WEST SUSSEX COUNTY COUNCIL CONSULTATION

TO:	Arun District Council FAO:
FROM:	WSSC - Highways Authority
DATE:	22 November 2019
LOCATION:	9-11 Abbeyfield Richmond Avenue Bognor Regis PO21 2YE
SUBJECT:	BR/145/19/PL Conversion of existing vacant residential care home into 8no. flats. An amended contractors site plan received.
DATE OF SITE VISIT:	n/a
RECOMMENDATION:	Advice
S106 CONTRIBUTION TOTAL:	n/a

Construction Management Plan

CONTRACTORS
SITE PLAN

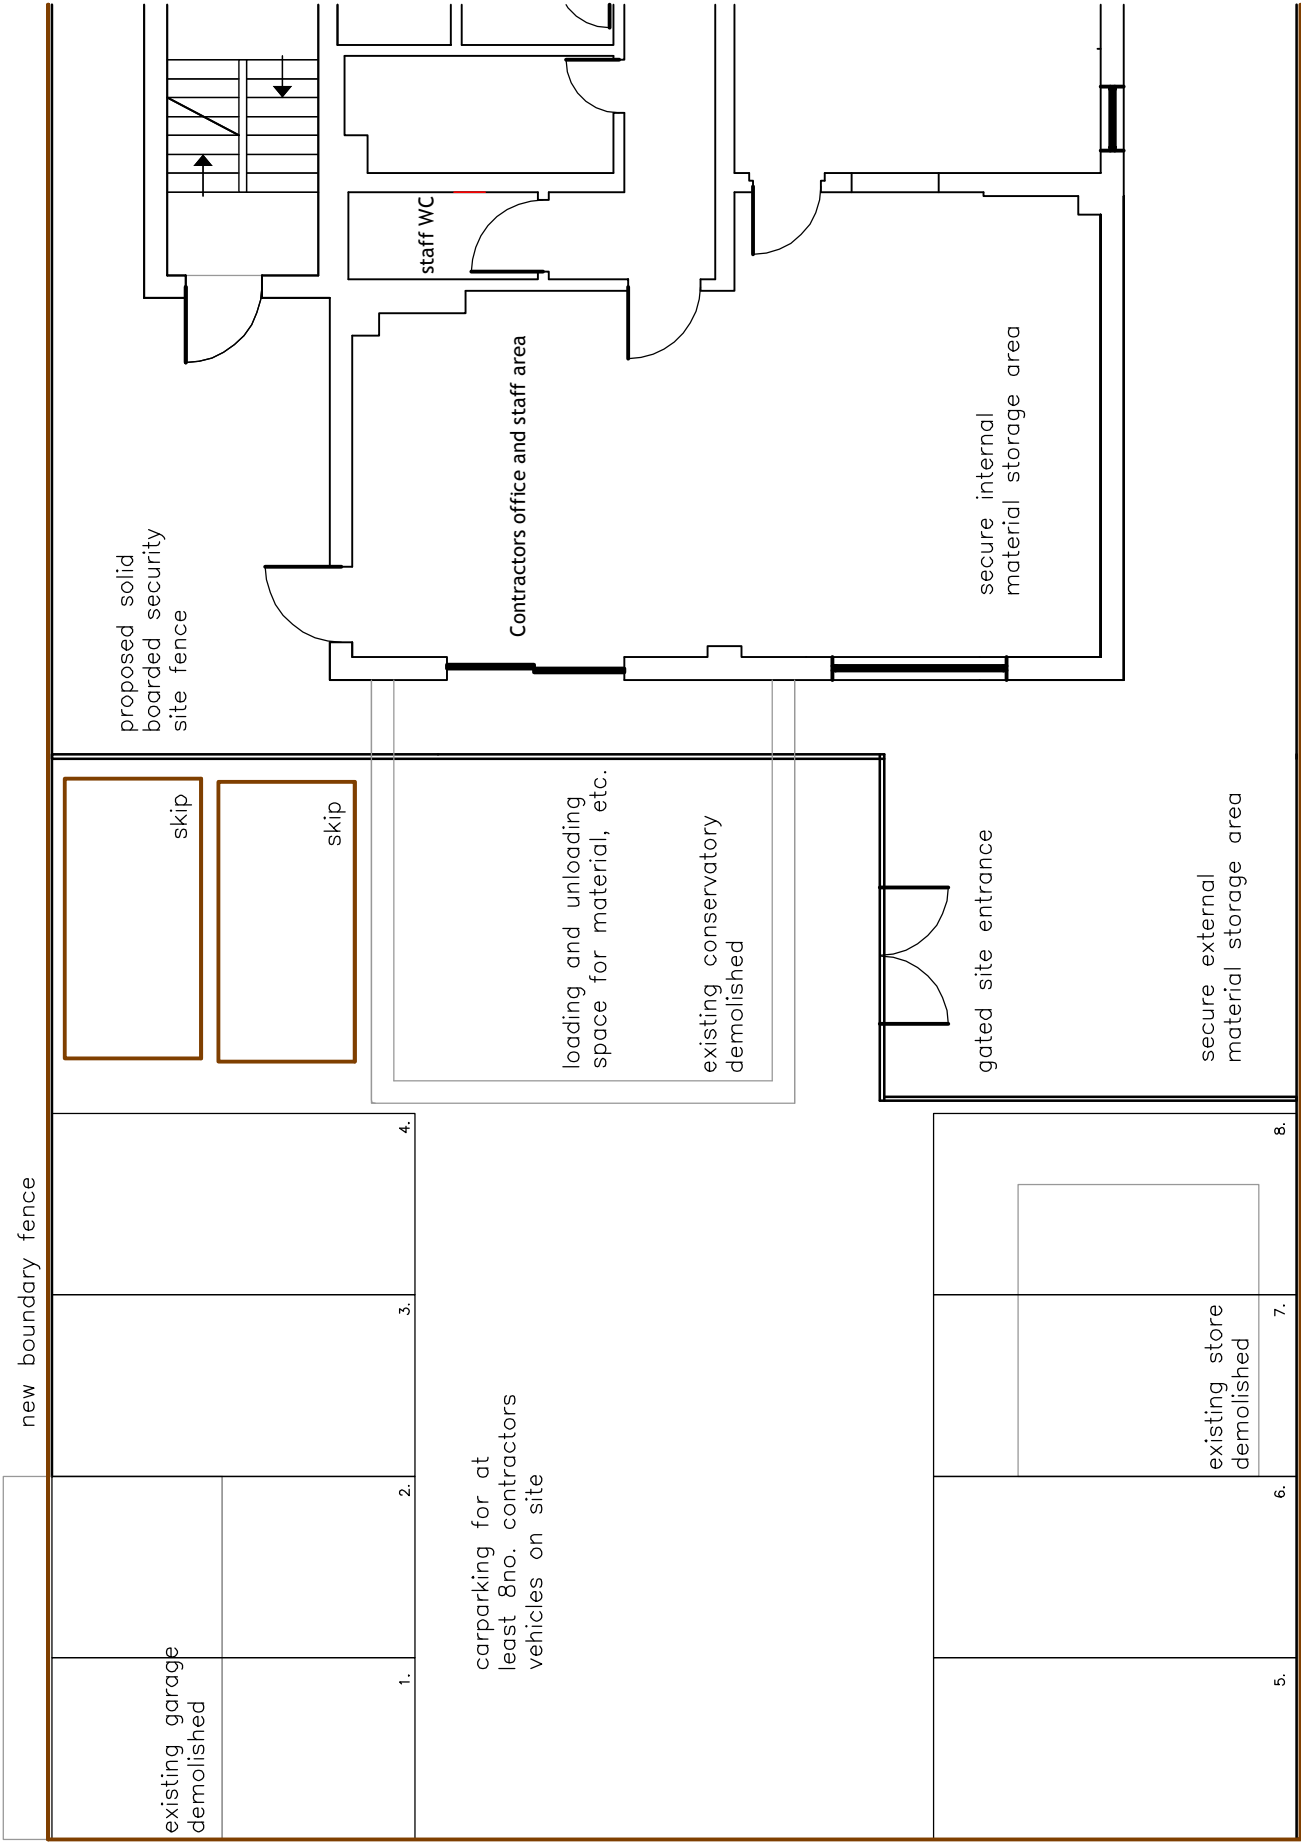
The applicant has provided additional detail relating to the access arrangements for the associated delivery vehicles. The details outline that vehicles at 2.2 x 4.8m will be anticipated once or twice a day. The site manager will be acting as a banksman for all deliveries to ensure that there are minimum conflicts within the access and site.

As most of the works at the site will be internal alterations, there will not be the requirement for a large number of lorries or trucks to deliver large bulky loads.

All deliveries will occur via the rear access route and will not take place at the front of the property where on street parking takes place and where vehicles could cause obstruction.

Based upon this, the LHA raise no highways safety concerns to this Construction Management plan.
